Plan Review, Inspection, and Permit Fees

Fire Marshal Division

Re: Mary Lane (Mary's Auction House)
4319 Ray Road
Spring Lake, NC 28390

Application Number 18-50043727

Application for Plan Review

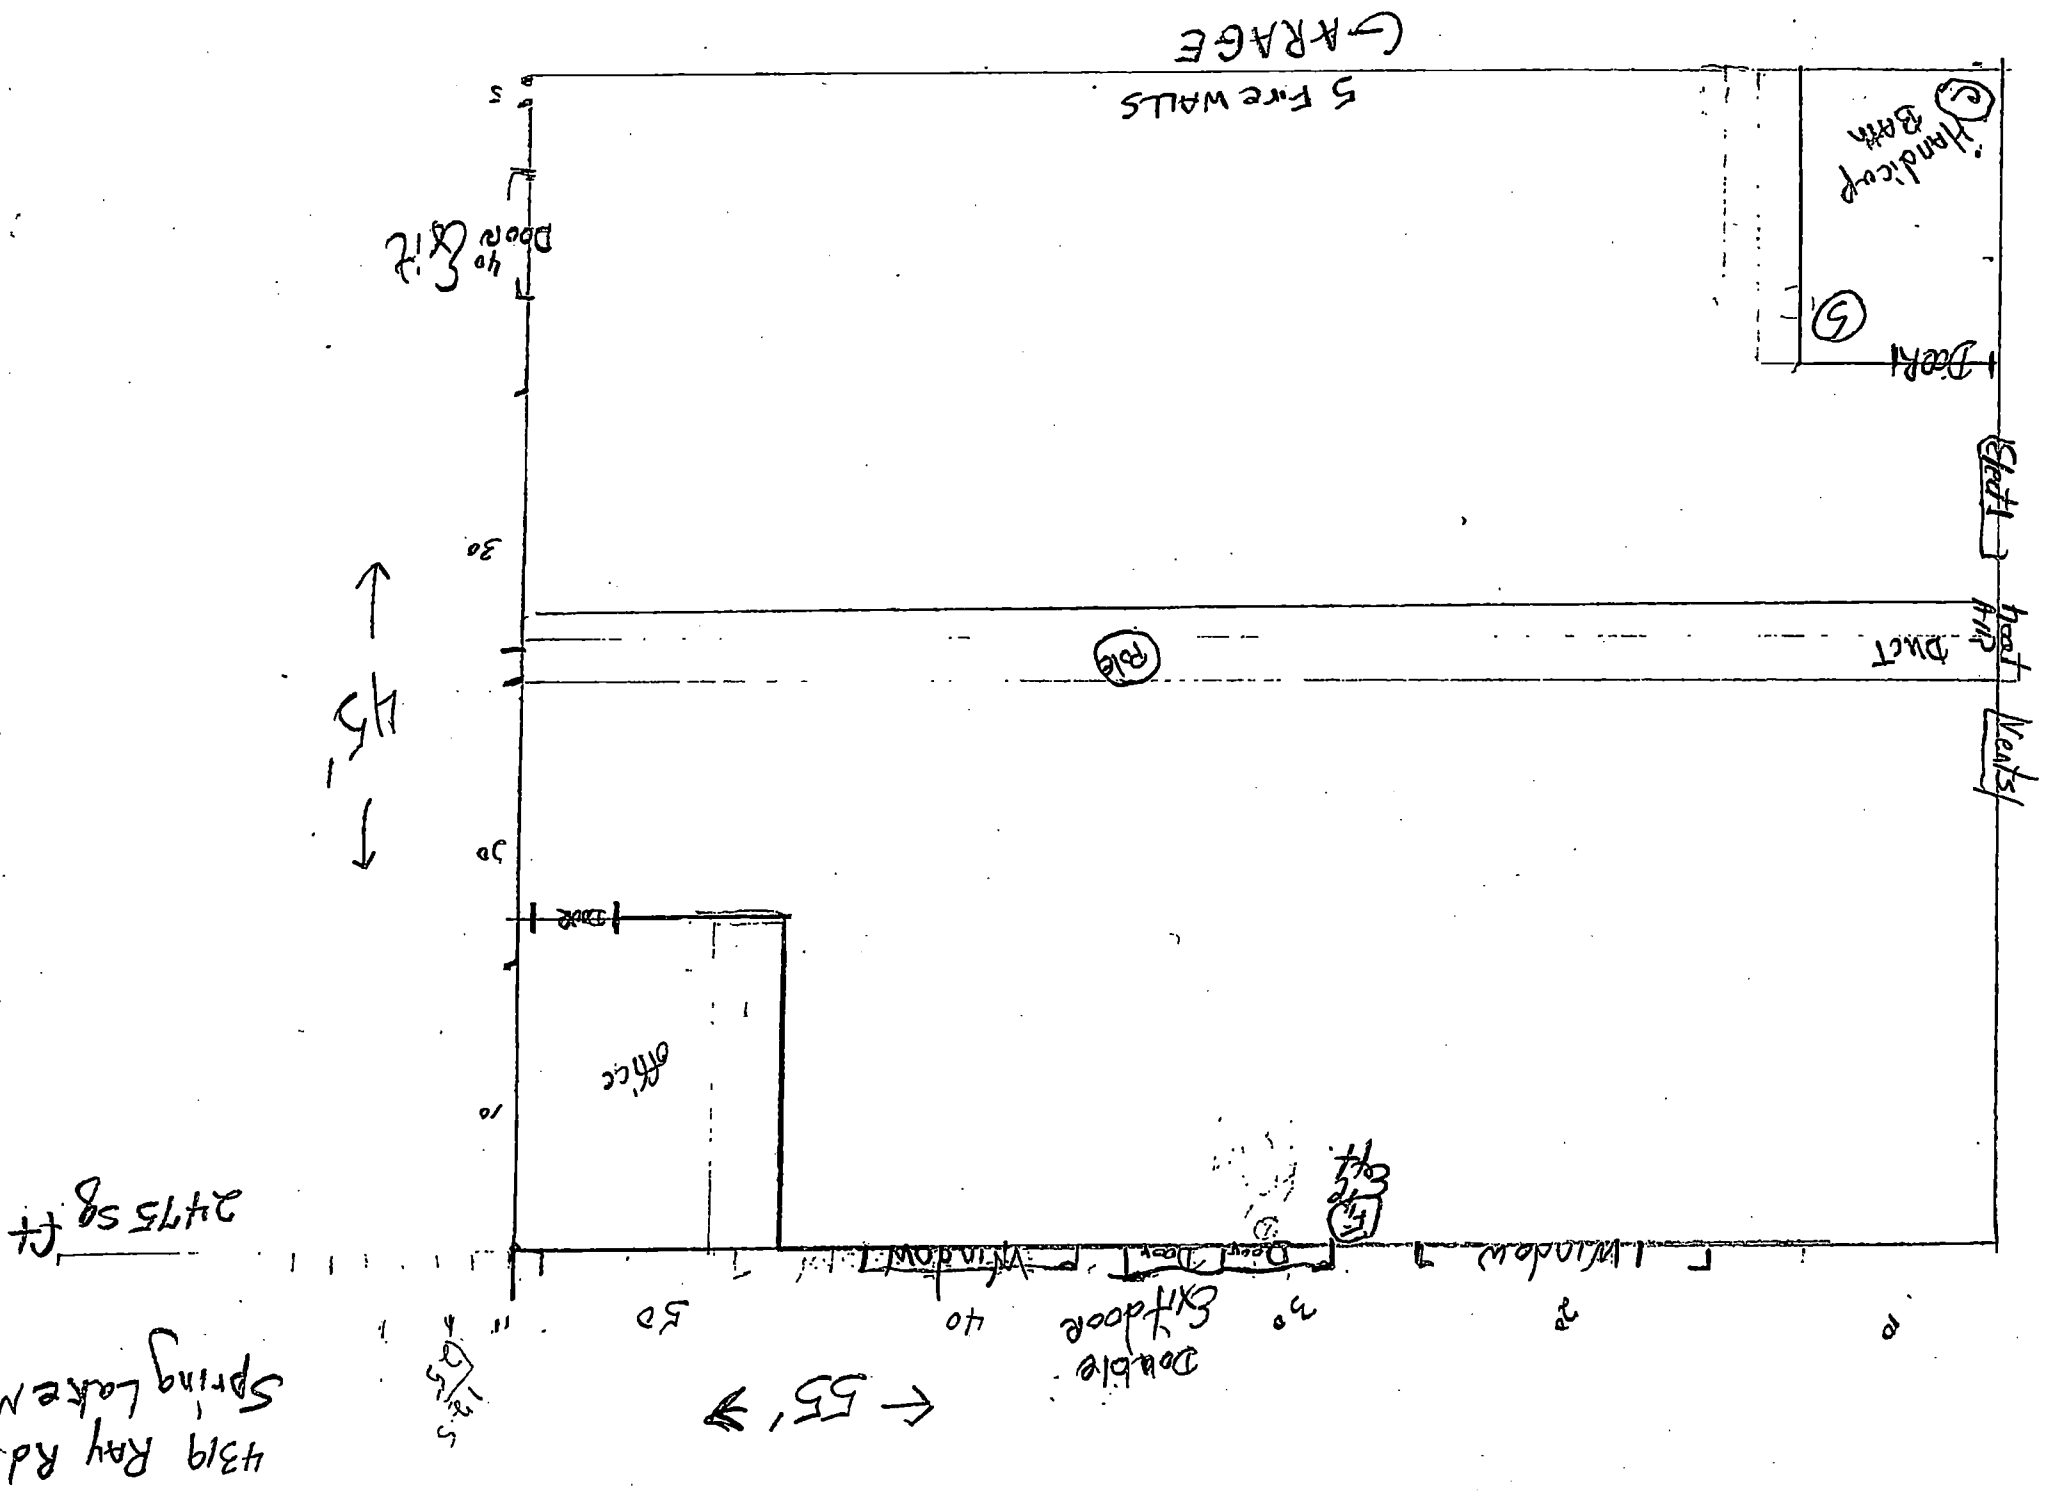
- Additionally Install (1) 2A10:BC fire extinguisher in the pool equipment room.
- All Fire extinguisher shall be properly mounted and tagged by a fire extinguisher company.
- Portable fire extinguishers shall be provided within a 30-foot (9144 mm) travel distance of commercial-type cooking equipment. Cooking equipment involving vegetable or animal oils and fats shall be protected by a Class K rated portable extinguisher.

- **1008.1.10 Panic Hardware**
 - UL 305 listed panic hardware is required on exit doors serving a room/space with an occupant load >49, also indicated on Building code summary. Panic hardware is not included on door schedule sheet B8 of Drawings.
